From: Anthony.Collier@hertfordshire.gov.uk
Sent: 10 April 2017 10:08
To: Planning
Subject: Planning application 6/2017/0504/FULL - Hertfordshire Constabulary

District ref: 6/2017/0504/FULL

Hertfordshire Constabulary
Stanborough Road
Welwyn Garden City
AL8 6XF

Alterations to existing highway junction, internal access road and car park, including replacement parking spaces, and erection of new security fencing and gates.

DRAWING TITLE  
Proposed Replacement Parking Area to South East Corner of Site

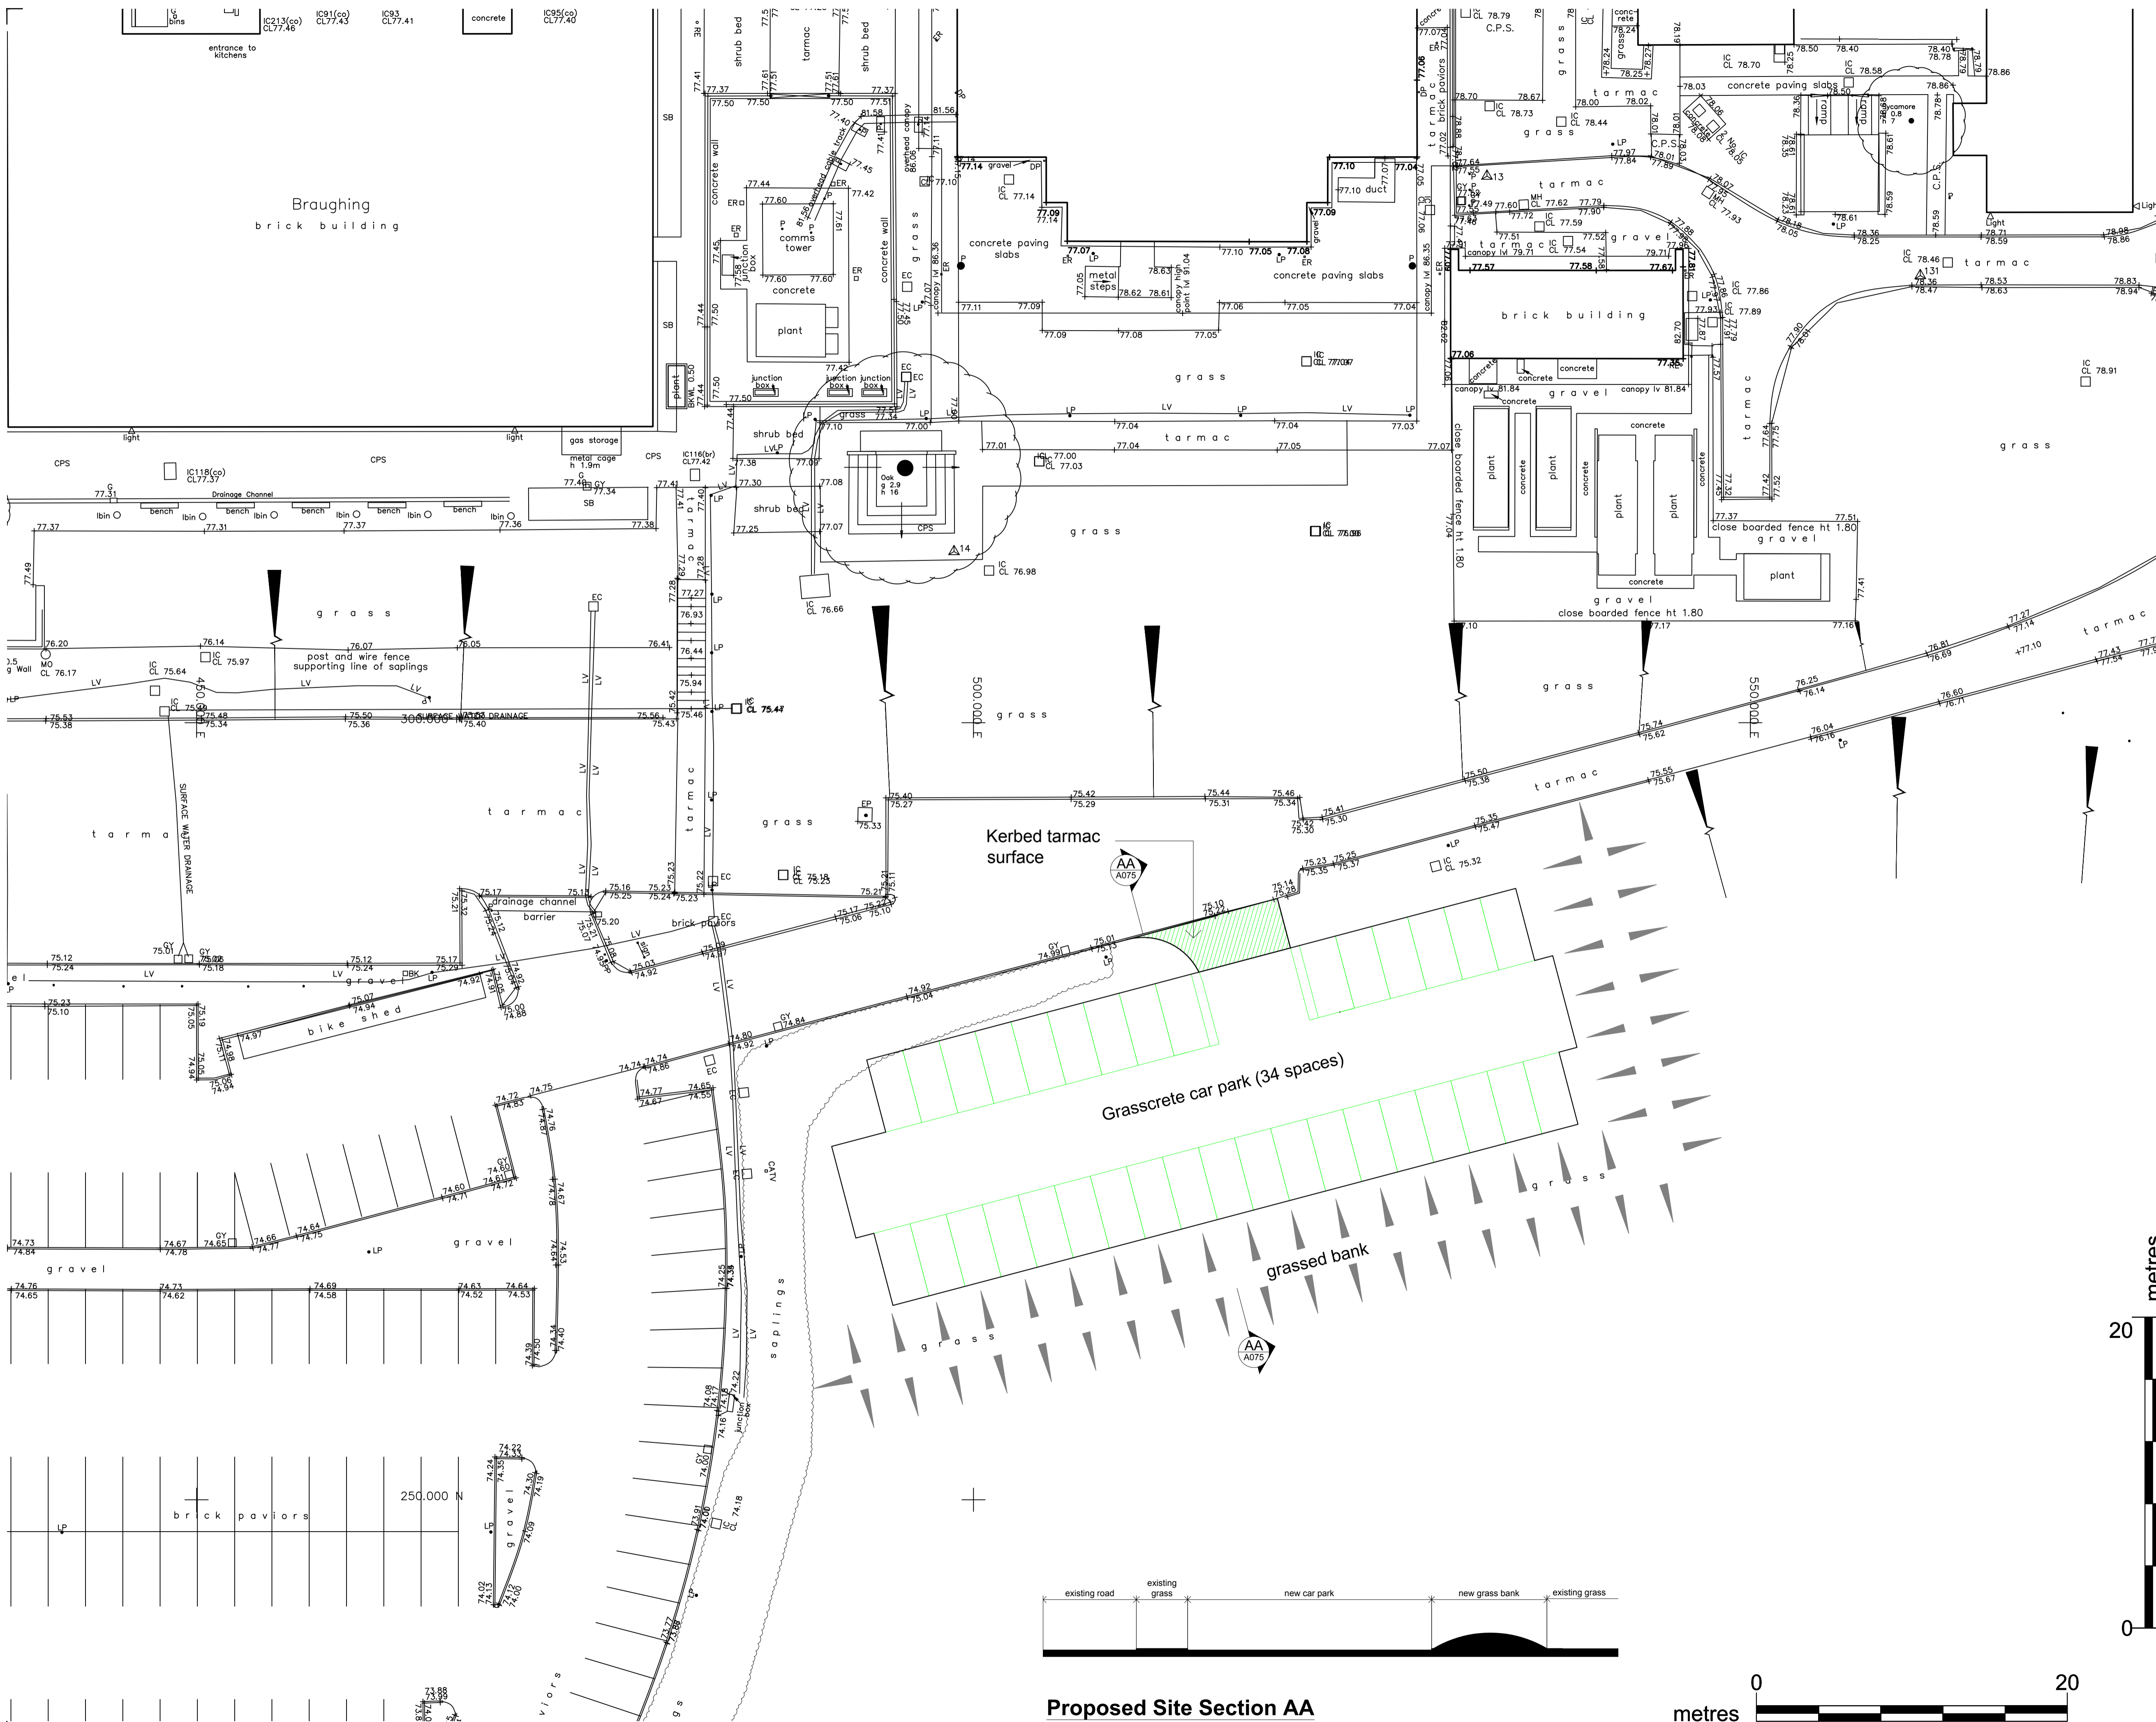
Parking is suitably laid out with manoeuvring space, dimensions of spaces are to standard. The LPA would be advised to review the parking provision.
